**Re: Proposed Dunkin Drive-Through,
9700 Central Ave. SW
Traffic Impact Study draft, HT#K09D054
Report dated February 26, 2024**
Engineer's Stamp -----
Via email laboona@koainc.com

The subject Traffic Impact Study draft received 2/27/2024, has been reviewed by the City of Albuquerque Planning Development Transportation Section. The City has the following comments to be addressed.

Site Plan

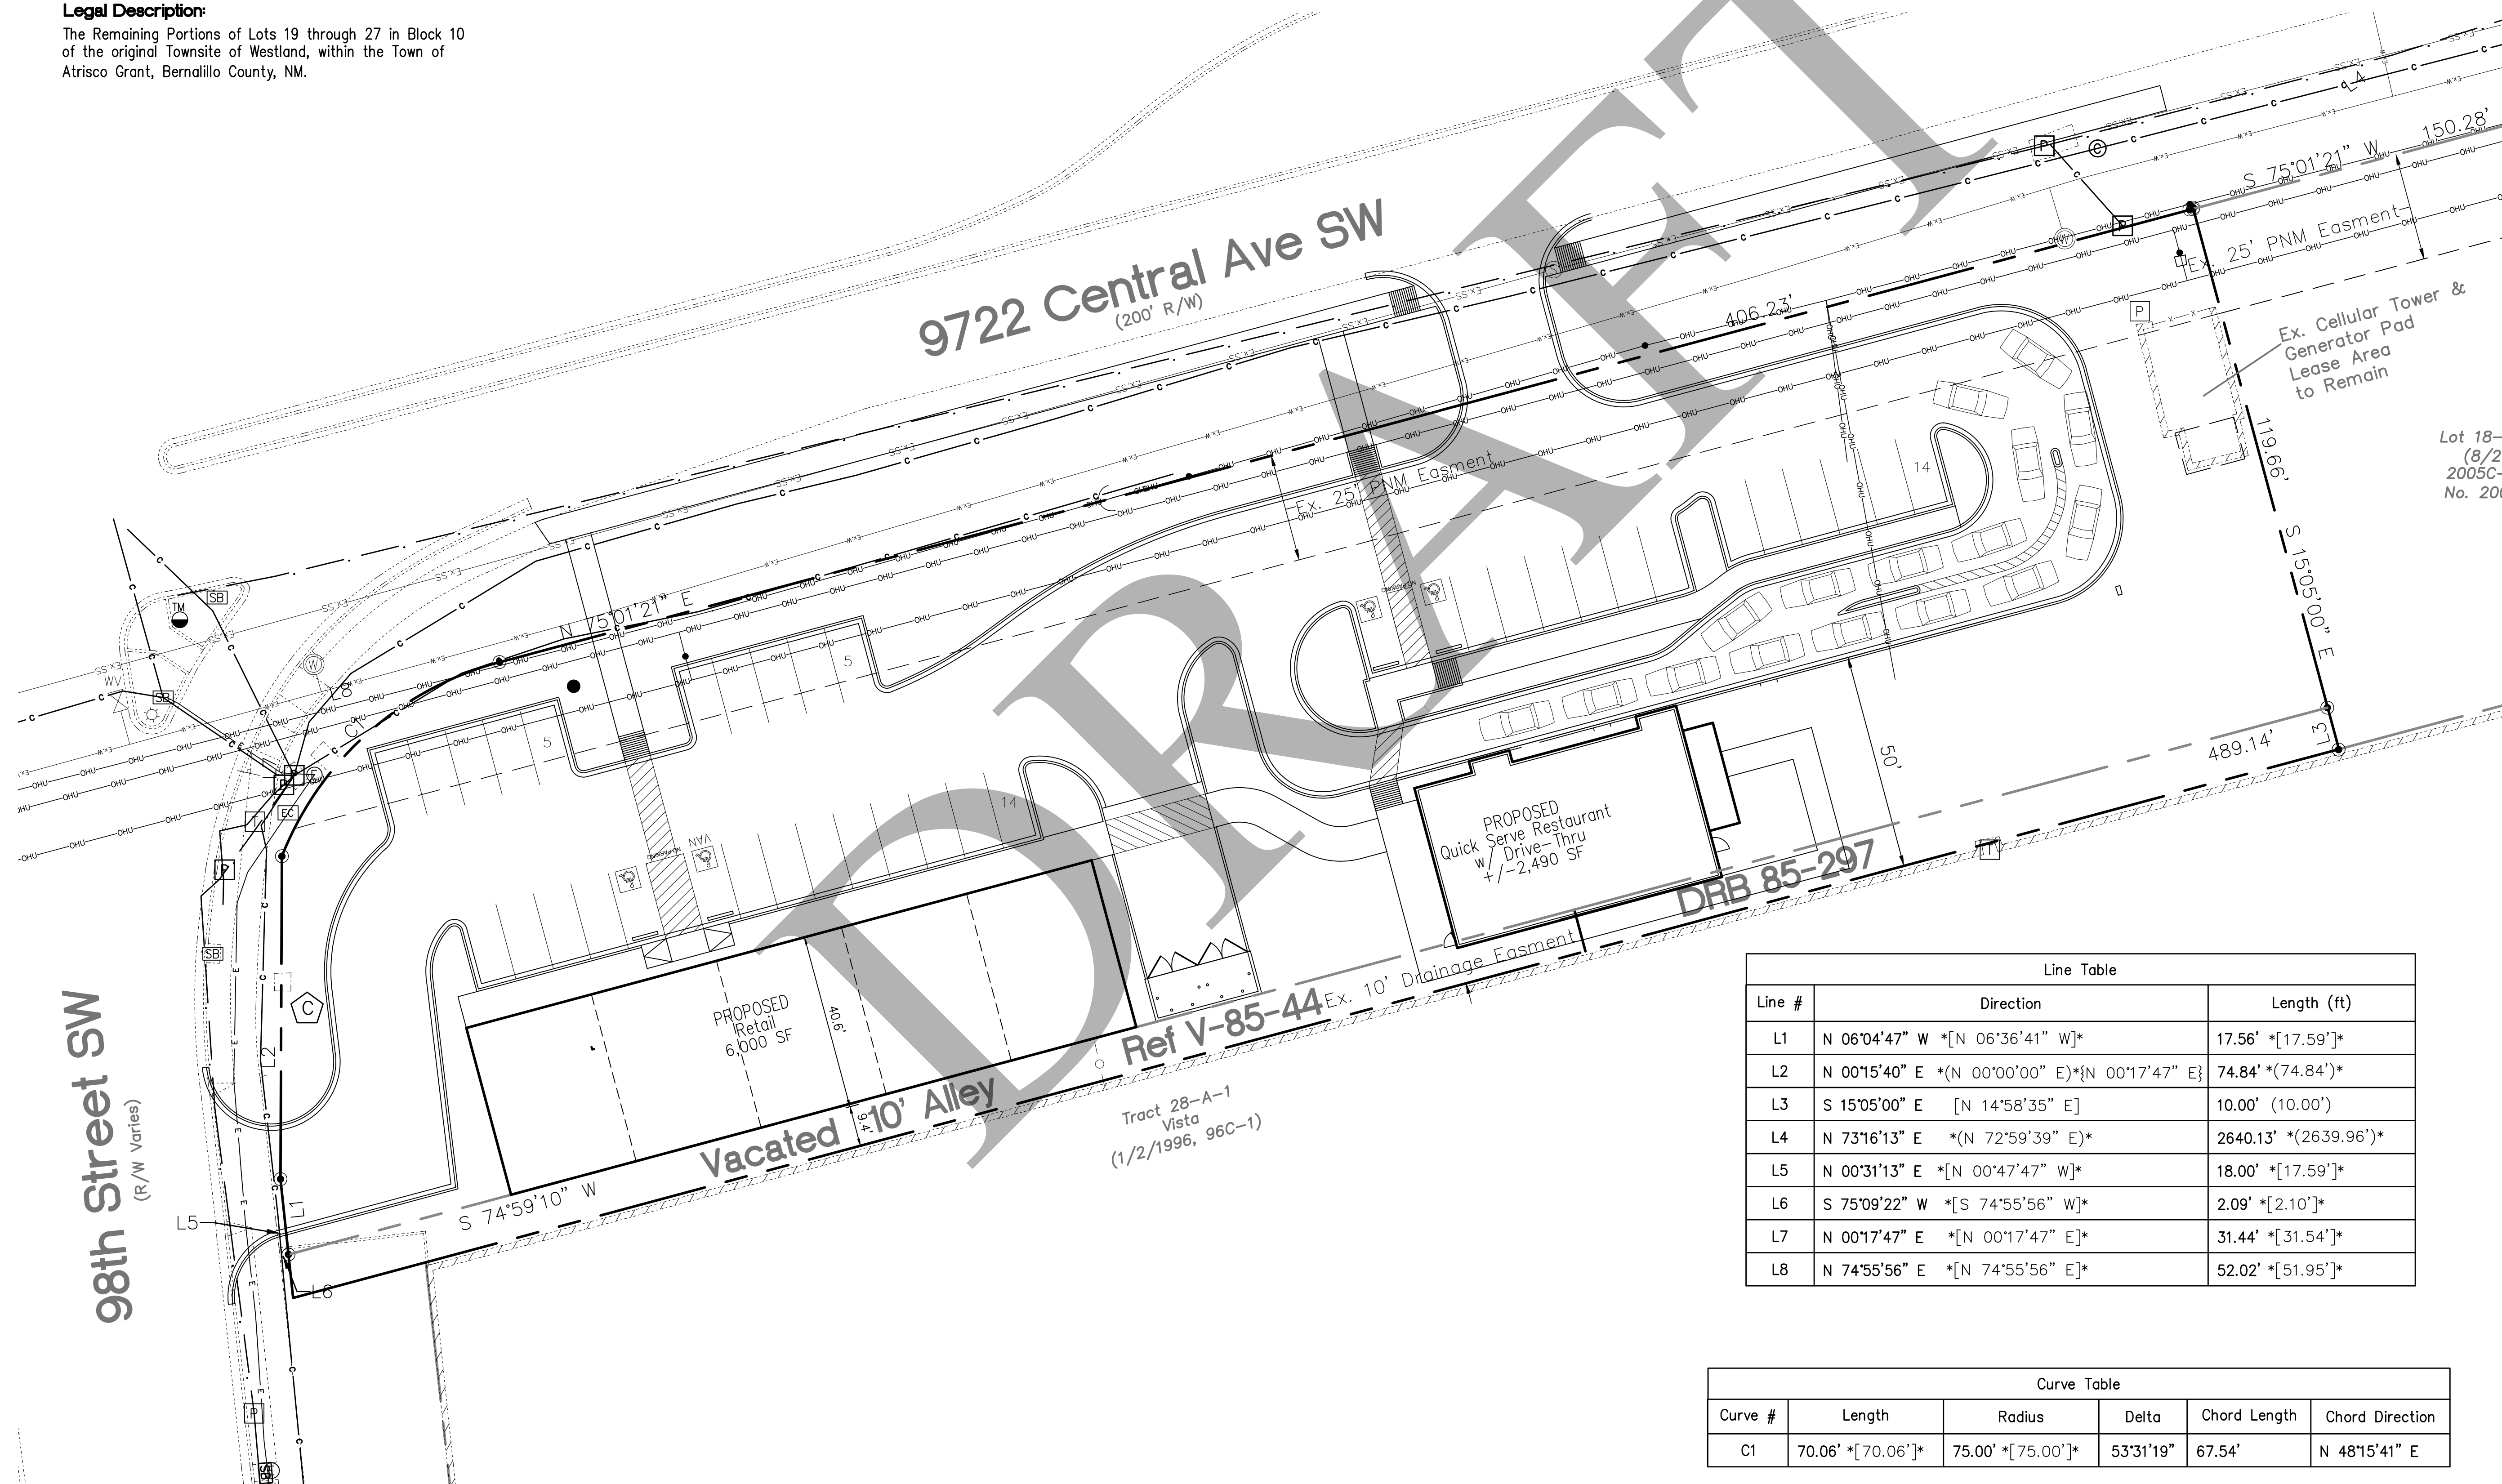
1. A proposed driveway on 98th St. is located too near the intersection of Central Ave. and 98th St. The City's Development Process Manual (DPM) in *Table 7.4.54 Minimum Distance Between Commercial Site Access and Intersection* requires the access distance to be a minimum of 300 feet from the approach of the intersection. The existing driveway on 98th St. is approximately 125' south of Central Ave. Correction is needed in the report on page 11 where it claims that the existing driveway on 98th St. is 175' south of Central Ave.

2. The existing auxiliary right-turn lane length is deficient in length. The COA DPM section 7-4(l)(7)(iii)(d) *Right-turn Lane Design* defines the minimum turn lane lengths in *Table 7.4.68 Right-turn Lane design Criteria*. A right-turn lane at this location should be at least 350 feet long with 600'-300' reverse Curve transition. The exiting turn lane length is approximately 240' with no transition.

3. The proposed access on 98th St. is located within the existing northbound right-turn lane approximately centered in the auxiliary turn lane. Driveway access within a turn lane is not a normally acceptable condition. The TIS indicates in the Crash Data section of the report that the highest contributing factor for crashes at this intersection is due to Driver Inattention. Locating an access point within a turn lane under these conditions is unacceptable due to the location of the access mid-way of a turn lane and apparent poor safety history.

Items #1, minimum access spacing distance from an intersection, and Item #2, minimum length of a turn-lane, will require review and approval of a waiver by the City's Development Facilitation Team (DFT) before the TIS can be further reviewed for approval.

Item #3, access/driveway within an auxiliary right-turn lane is not covered in the DPM regulations but would be considered a Best Practice and sound Engineering judgement to prohibit a driveway in this location. Written approval from the City Engineer is needed to document acceptance this atypical driveway treatment.

Please address comment #1 and #2 through DFT waiver request and #3 by approval from the City Engineer. Further review of this TIS will not be performed until acceptable location of the 98th St access is proposed, the lengthening of the north to east right-turn lane is increased to meet the DPM minimums, and the access on 98th St. is not located within an auxiliary right-turn lane.
